**Re: Pulte @ Mirehaven Phase 2A
Erosion Sediment Control Plan
Engineer's Stamp Date 12-11-15 (H09E017E)**

Stormwater Quality provides the following comments on the ESC plan for the first phase.

| CITY PROJECT NO.                                                |                        | ZONE MAP NO.                                                      | ESC 104 |

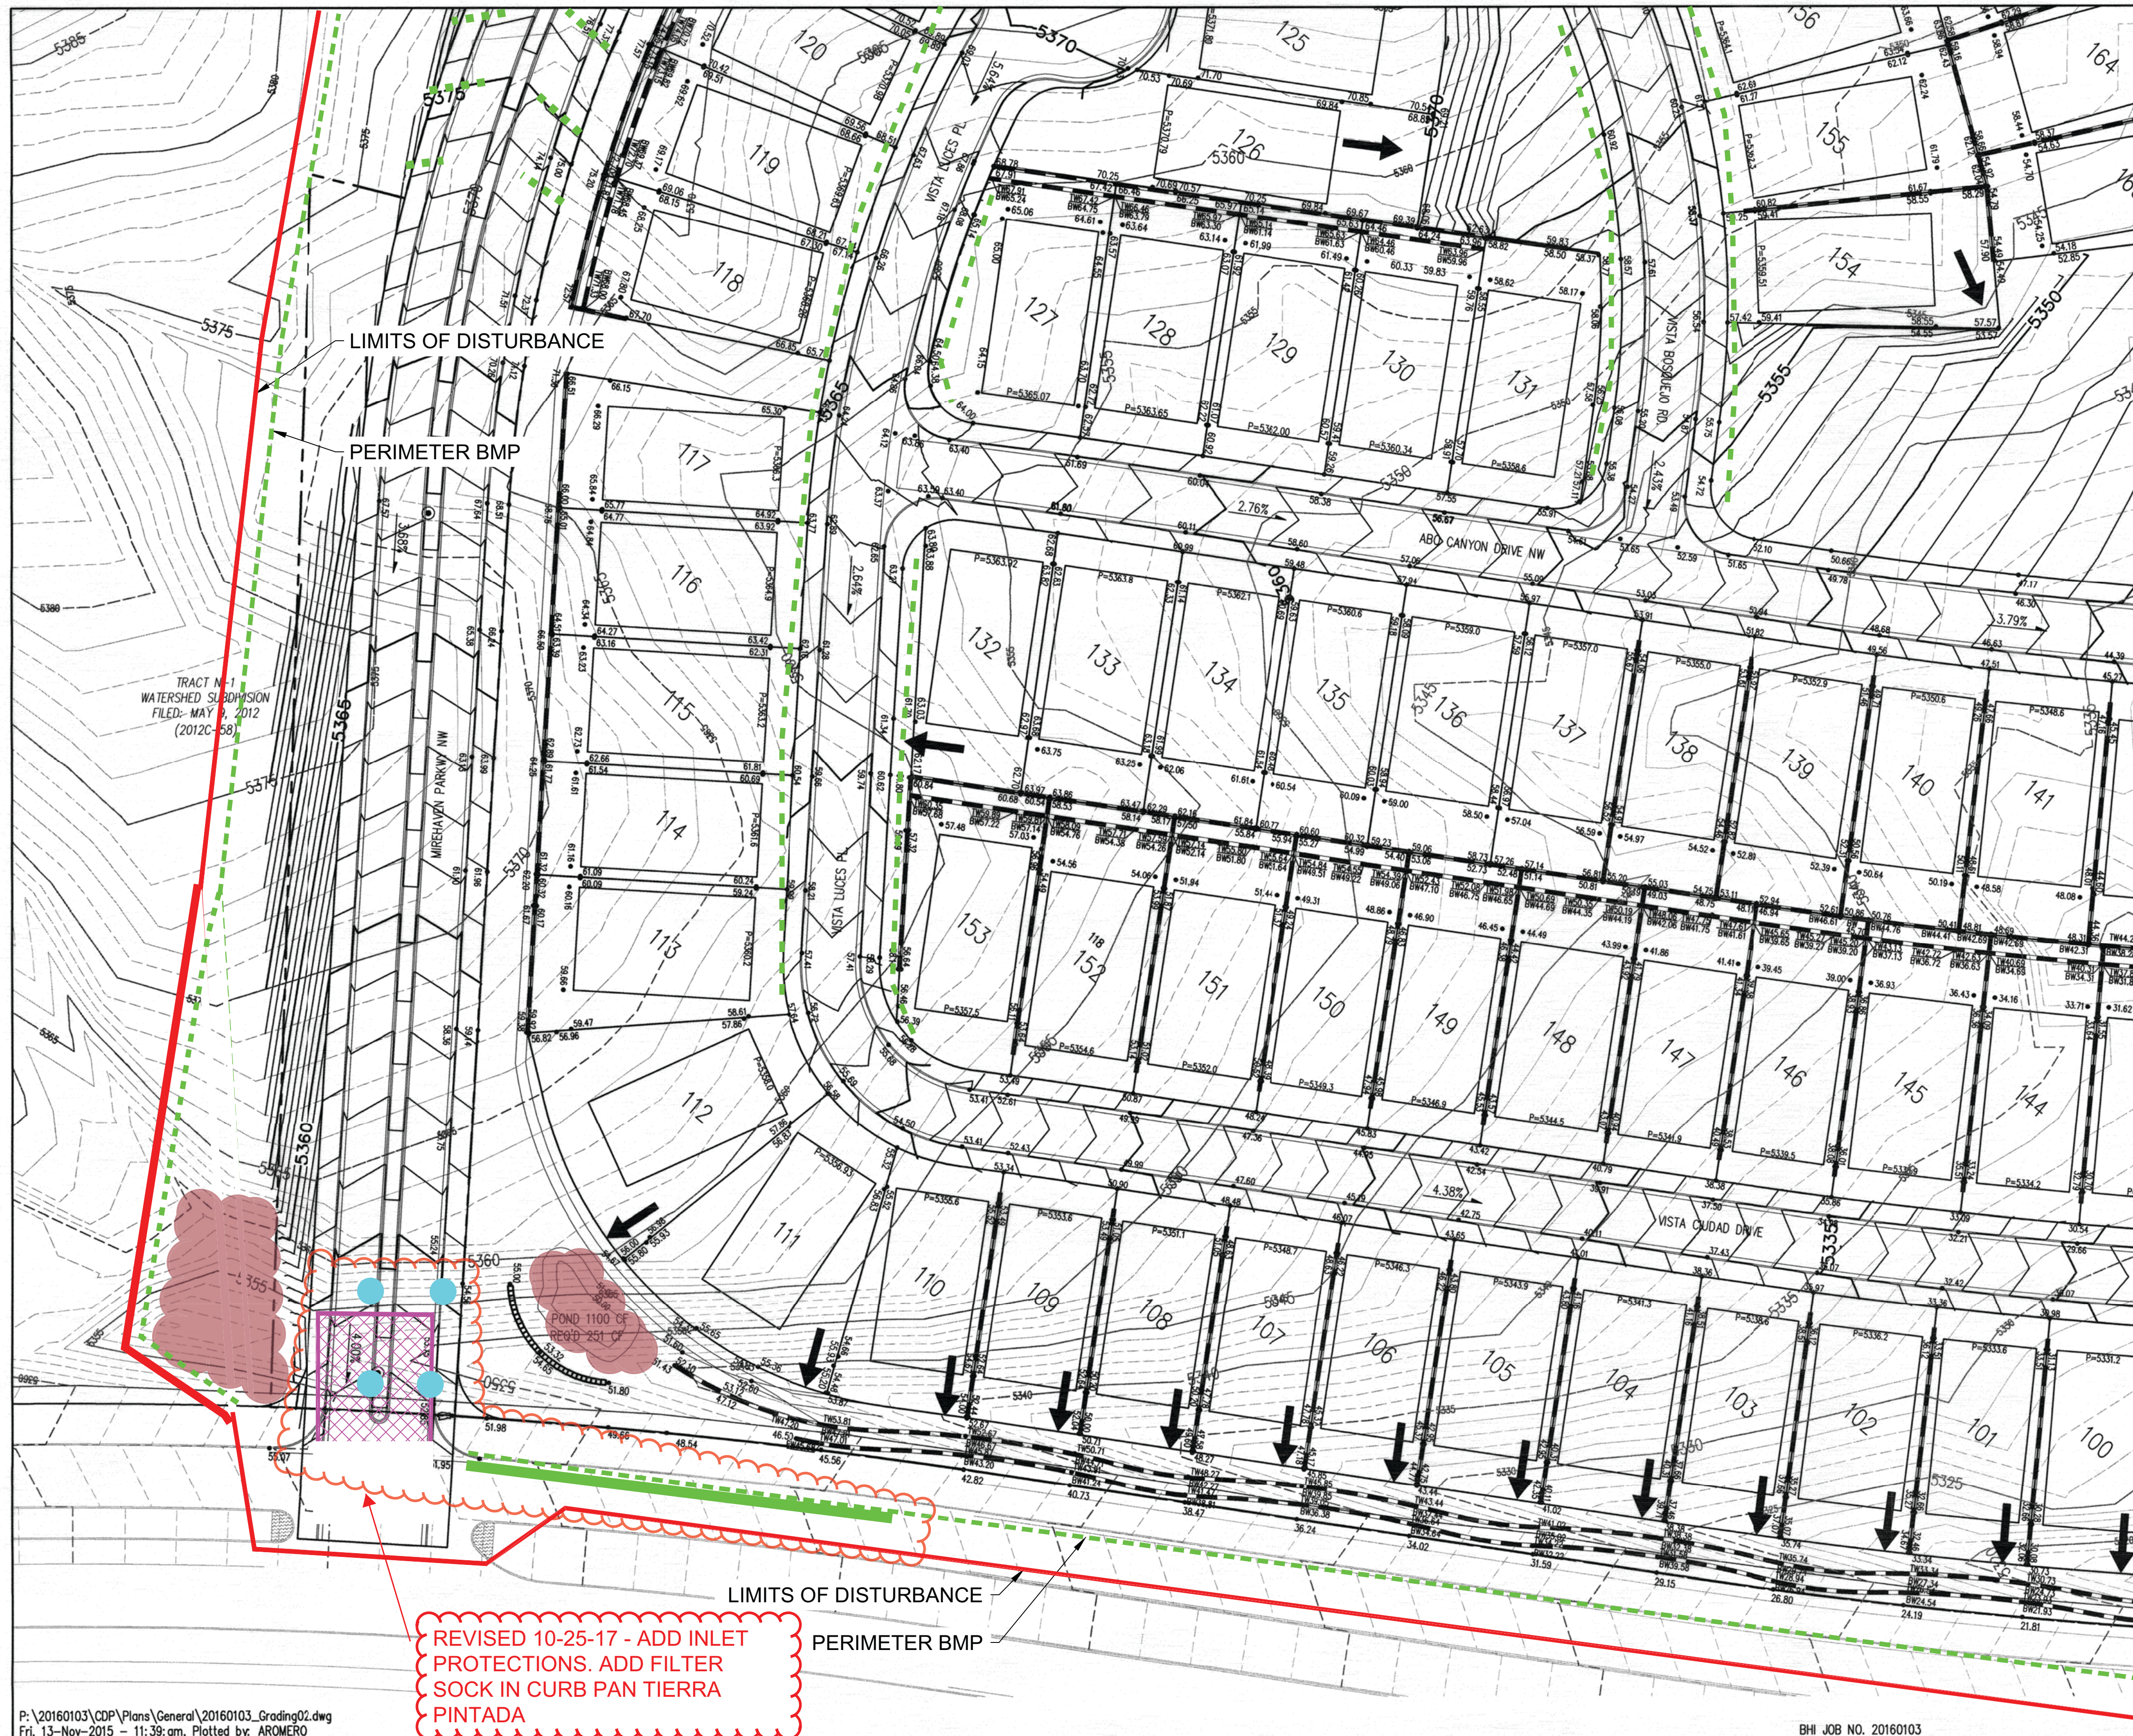
- a. Mirehaven Parkway has relatively long and steep sections that drain to existing roadways. Stormwater Quality has seen this at a recent project and a BMP(s) in addition to the entrance is required to keep sediment out of the streets. I've attached a photo of the project. An offline sediment pond, northwest of the entrance to Tierra Pintada could work. For the long run to the north since the grading plan shows an LID swale in the median, the contractor could grade the swale in the middle, then waddles could be installed every 100 feet or so.

- b. ABQ Canyon Dr is another long steep stretch. A pond or berm could be built at the downstream end.
- c. A pond or berm could be proposed at the north end of Vista Ciudad DR.

- d. It seems a BMP similar to the BMP at the north end of Willow Canyon Trl in Del Webb would work.
- e. There is currently an open storm drain in the northeast corner. It is in a sediment pond, but could probably use a large wattle.

- a. Provide inlet protection for street inlets. The green L-shaped ones appear to work that Superior is currently using, but I don't see them on the detail sheet. I saw note 13, but all inlets are susceptible to an inflow of sediment and showing the location (IP) on the plan would be more effective than a note.
- b. A BMP should be proposed in the front yards perpendicular to the street along the steeper streets (slope > 2.5%) to slow down the water and prevent sediment from depositing in the street at the bottom of the hill. Note 6 speaks to this, but it is not clear how it will be implemented and leaving it up to the contractor does not appear effective based on over 200 field inspections. BMPs similar to Valle Vista may be effective.
